7 April 2026

Submission on State Significant Development Mamre Road Data Centre Campus (SSD-92743706) at 706-752 Mamre Road, Kemps Creek

NSW Ports **objects to the proposal**. The subject land is strategically located immediately adjacent to the future Western Sydney (Mamre Road) Intermodal Terminal and forms part of a precinct specifically planned and protected for freight and logistics uses. The proposed development would permanently lock the land required to support the delivery and operation of this nationally significant freight infrastructure. The proposal is inconsistent with the strategic planning framework, government policy direction and statutory controls that apply to the Mamre Road Precinct.

Figure 4. Proposed development plan - Data Centre Campus

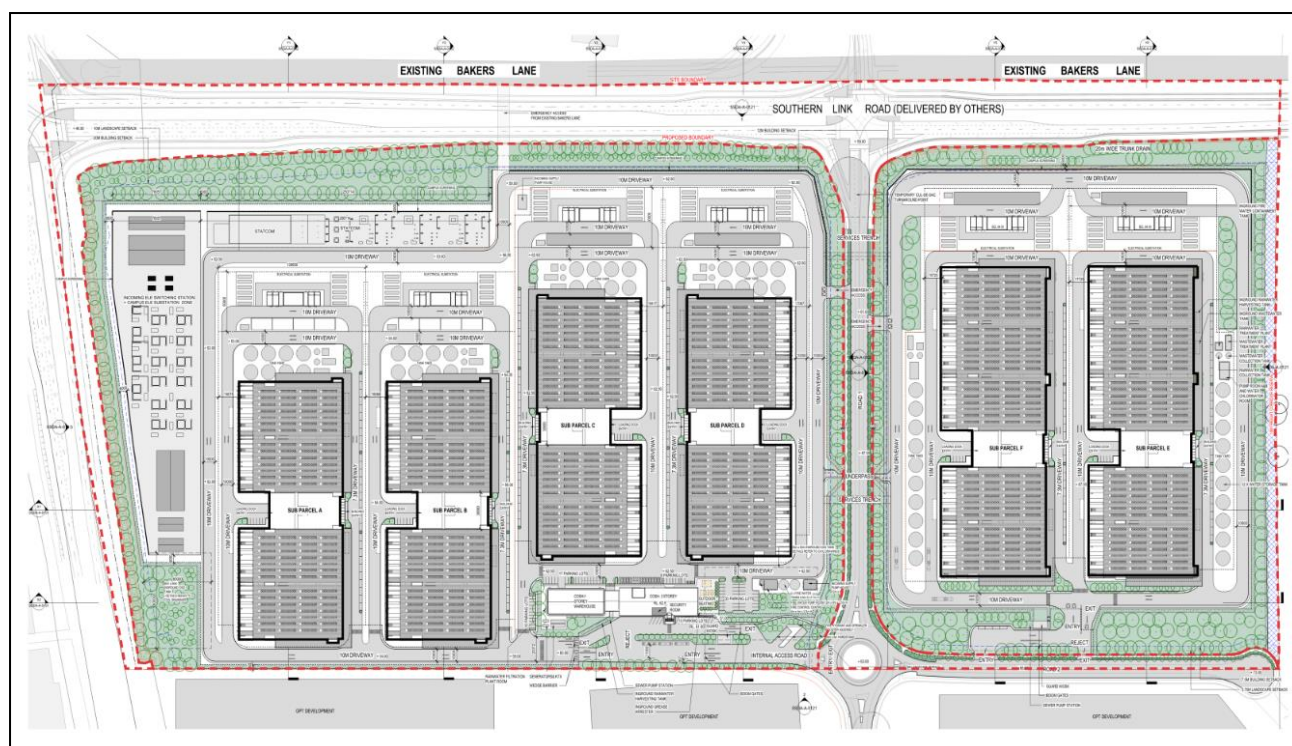
The proposal does not meet Objective 3.4.2 of the Mamre Road DCP. The site is part of the 'dedicated freight network' as it is serviced by the proposed dedicated freight corridor. The proposal has not demonstrated how access to and from the dedicated freight corridor will be achieved as required under Control 5 of the Mamre Road DCP which states:

"Development applications for lots with an identified access point (refer Figure 17) shall demonstrate how access to and from the dedicated freight corridor will be achieved"

Additionally, the proposed Road 2 encroaches within the required 10m reserved freight corridor.
